From: Nicholas Moss [REDACTED]
Sent: 04 April 2019 15:38
To: Charlotte Easton <Charlotte.Easton@arun.gov.uk>
Subject: Re: 7 Lincoln Avenue, Aldwick - AW/57/19/HH

I write to you regarding the application you have submitted for 7 Lincoln Avenue, Aldwick – reference AW/57/19/HH.

BLOCK/SITE PLAN
 AREA 90m x 90m
 SCALE 1:500 on A4
 CENTRE COORDINATES: 490380, 99423

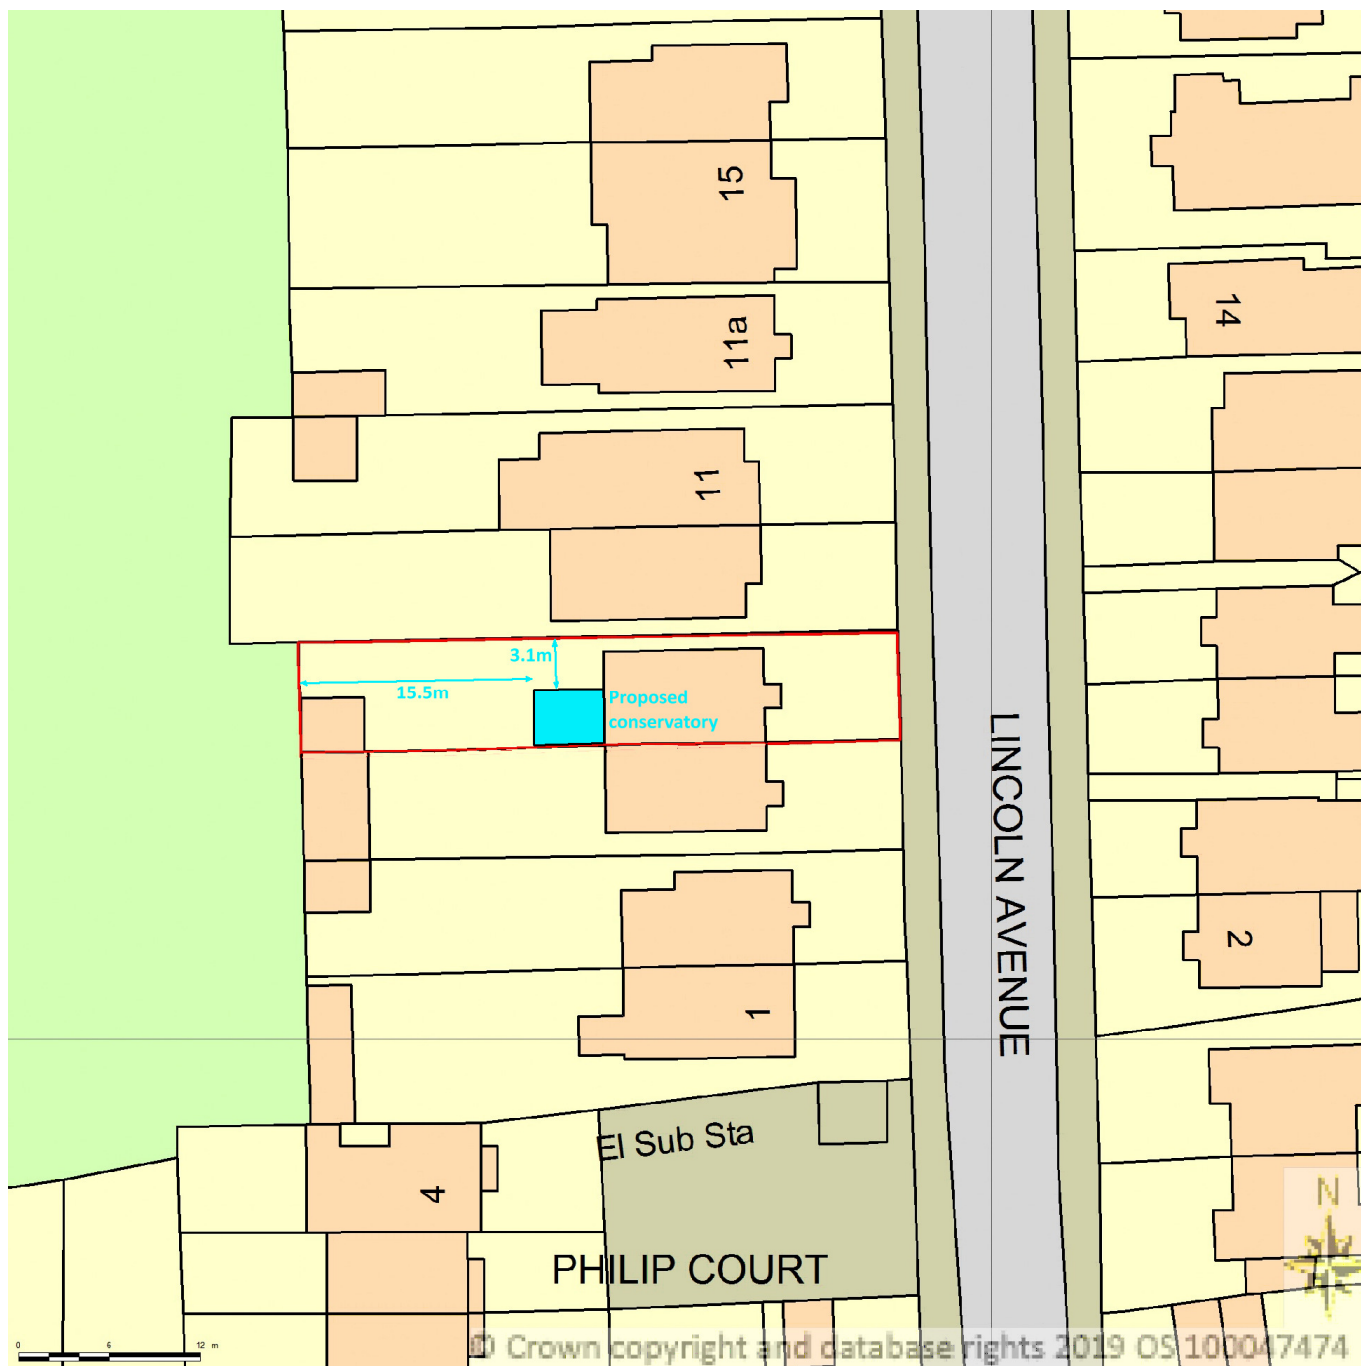
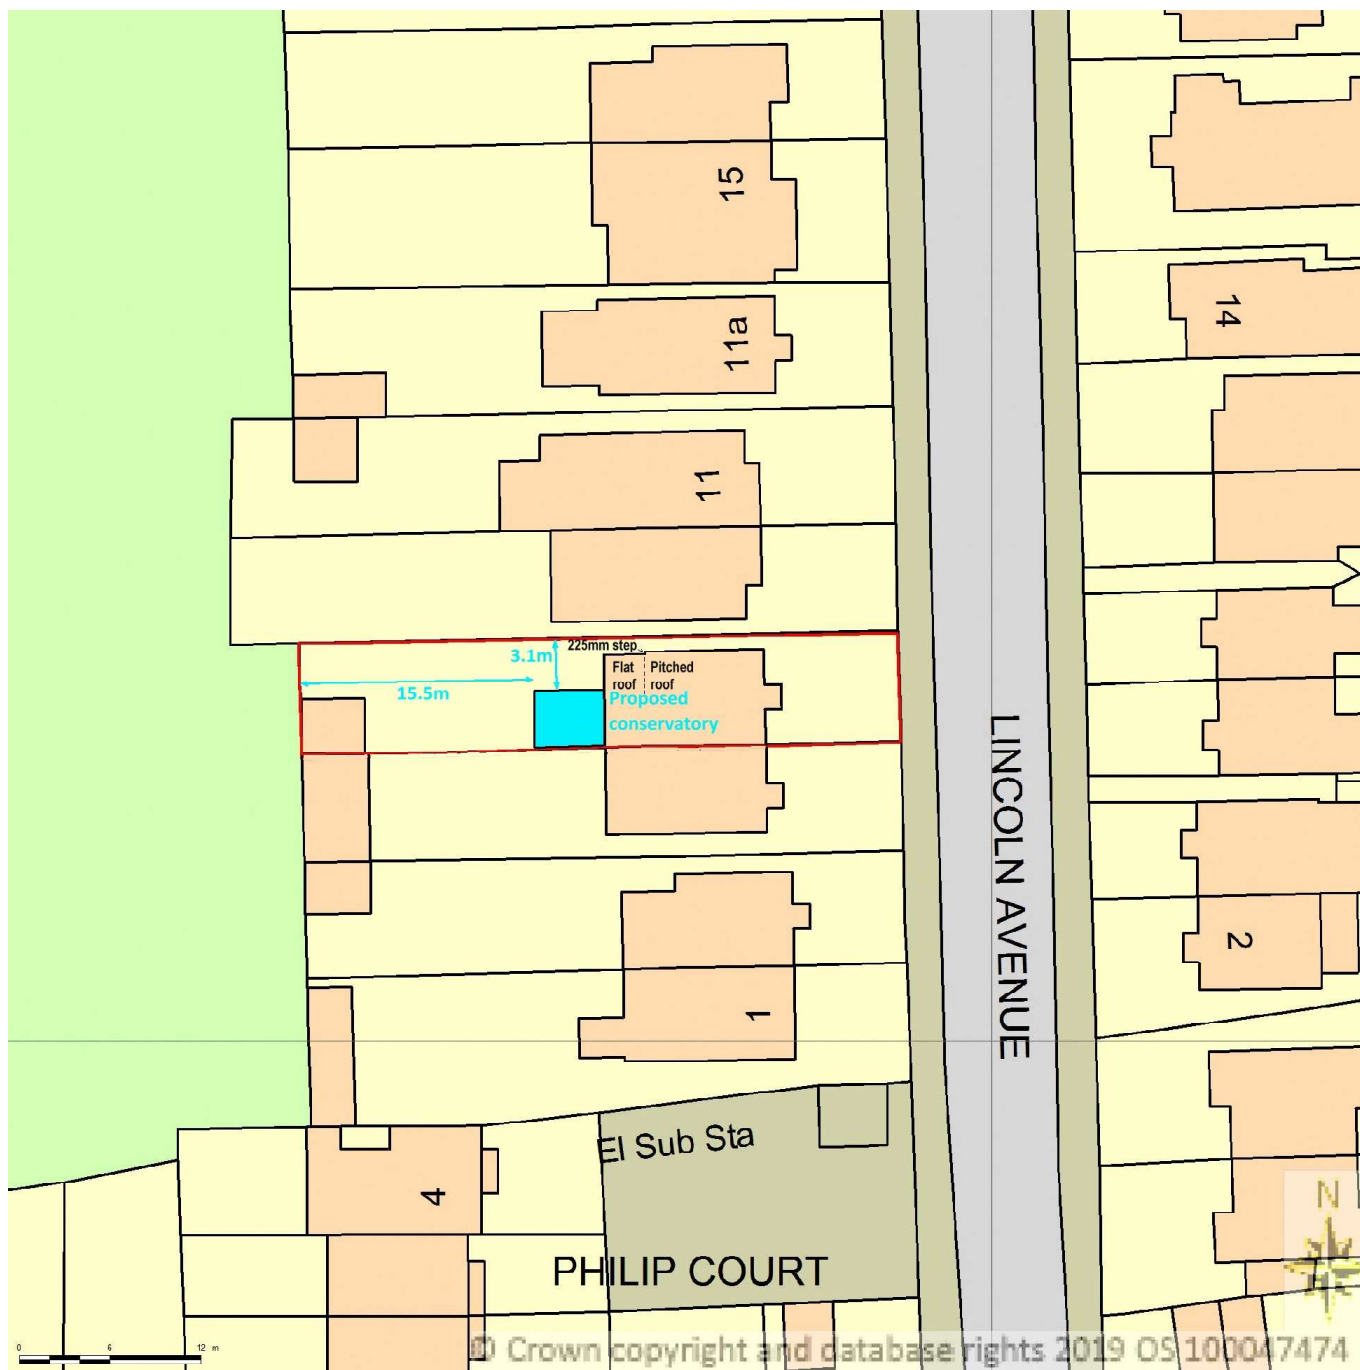
Having looked at the application we have some concerns the Block plan submitted does not coincide with floor plans, the floor plans seem to show the flat roof part of the existing dwelling to be slightly set in from the main bulk of the dwelling. Could you please send in a revised drawing with the amendment – if you are unable to show this given the small scale could you please annotate the drawing.

Please find attached the revised block plan and photograph as requested.
